Application for removal or variation of a condition following grant of planning permission. Town and Country Planning Act 1990. Planning (Listed Buildings and Conservation Areas) Act 1990

Demolition of existing changing rooms and construction of new changing rooms and community/sports facility.

Application reference number:	LU/283/11	Date of decision:	01/12/2011
-------------------------------	--	-------------------	---

Rev	Date	By	Revision Notes	Client	Chd	Client	By	TH
A	15/01/11	EW	Revised plan	Southfist Recreation ground	SF	Southfist Recreation ground	By	TH
				Proposed Section AA		Proposed Section AA	Chd	SF
				Drawing Number	1051 (GA) 15	Rev	A	Scale 1:100 @A3
								Date 30/09/11

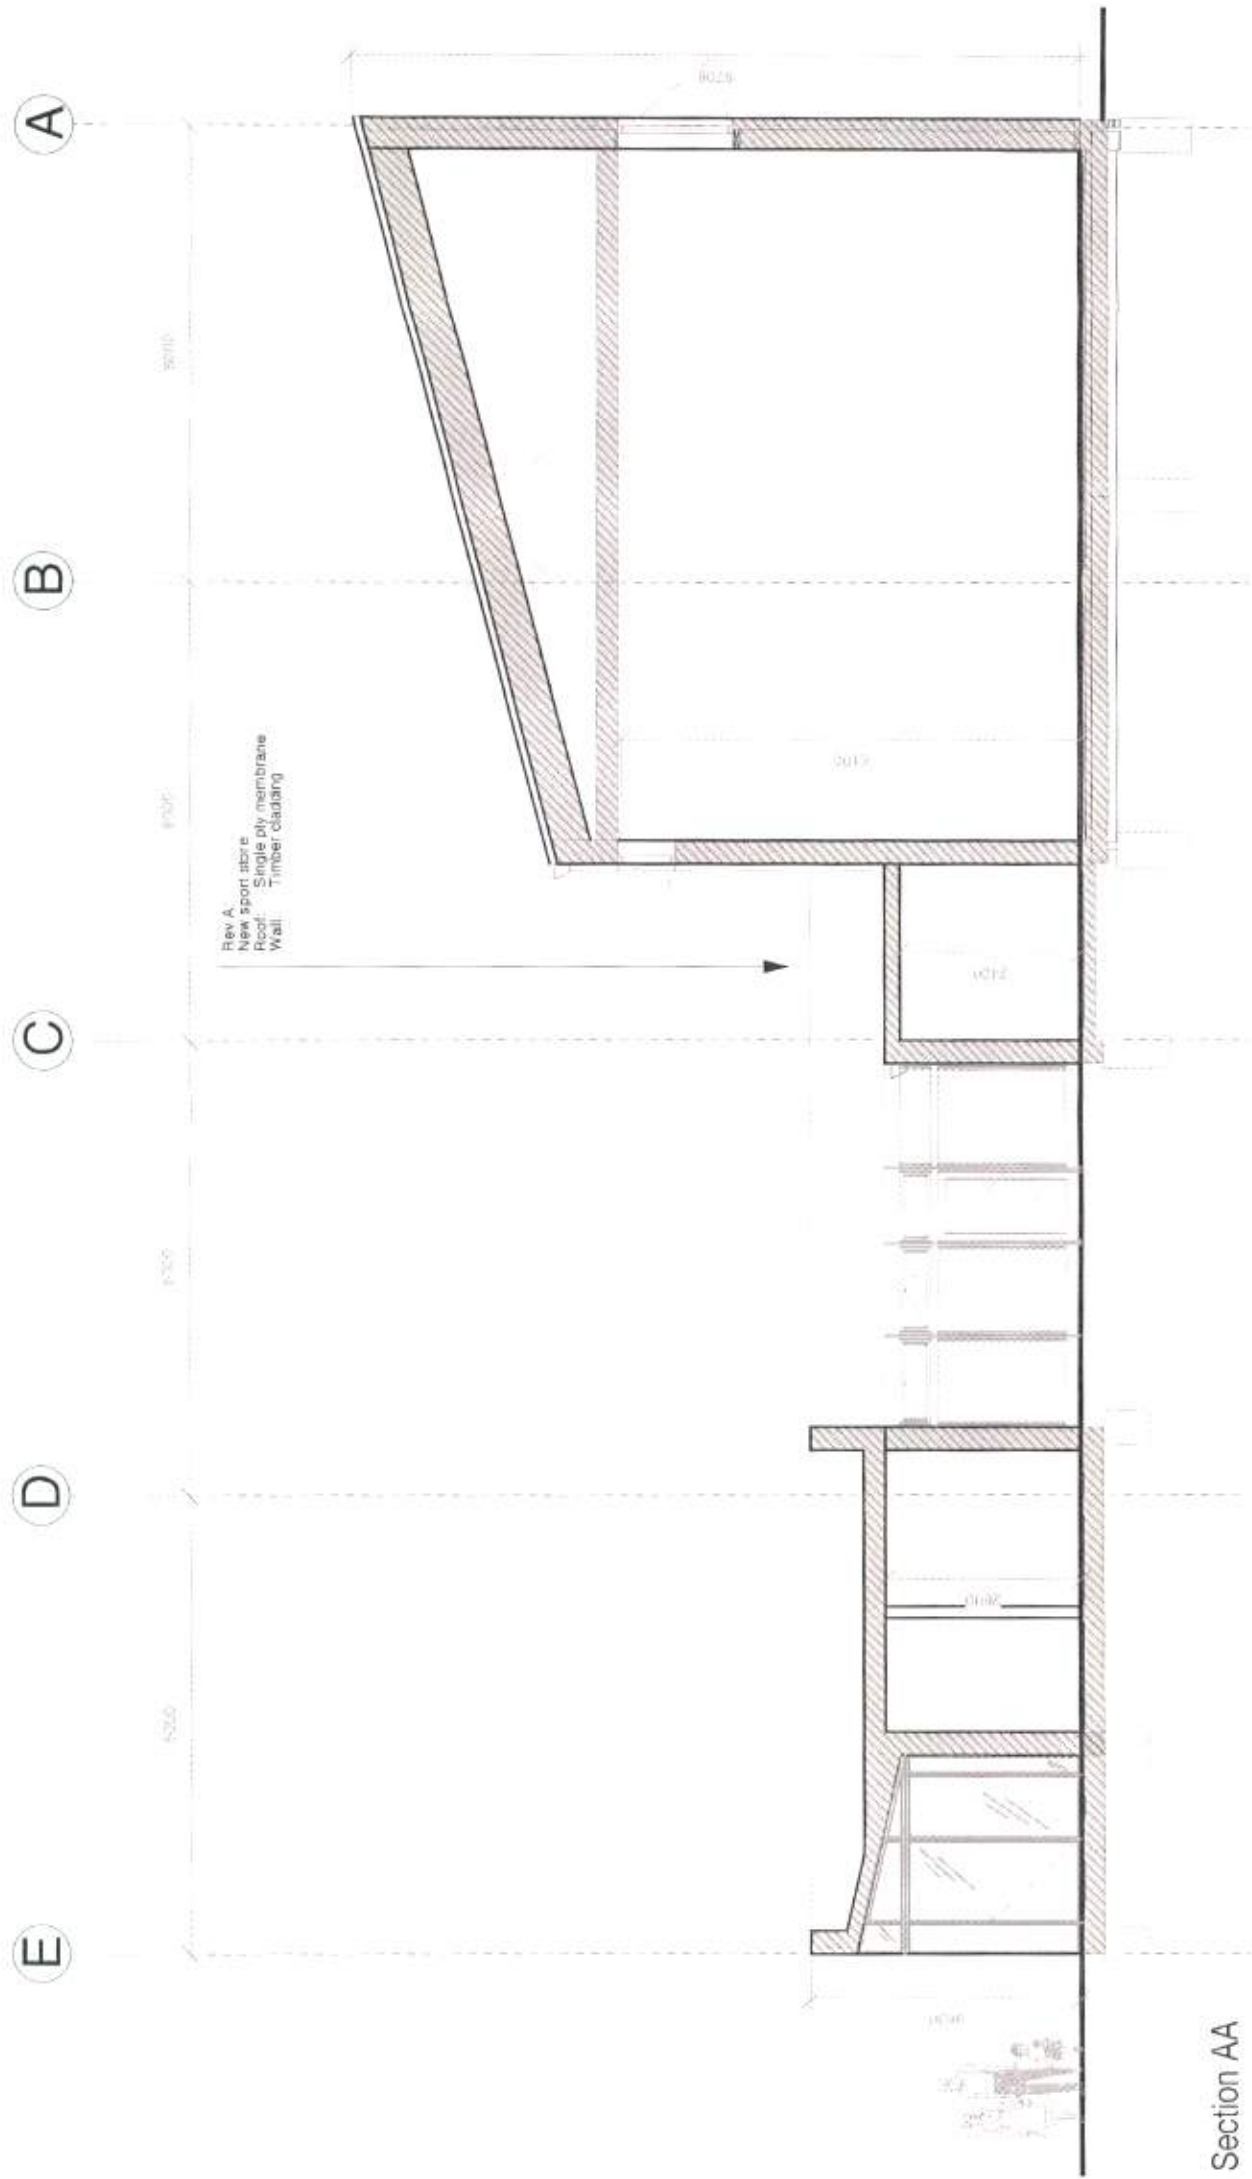
Condition 2 - As a minor Material amendment to an existing approval LU/283/11.
Amendments
1. Addition of a storage area within the enclosed courtyard (as requested by user groups).
2. Windows alignment and location.
3. External kitchen door.
Please refer to drawings - 1051 (GA) 05E, 06A, 07A, 15A and 16A enclosed.
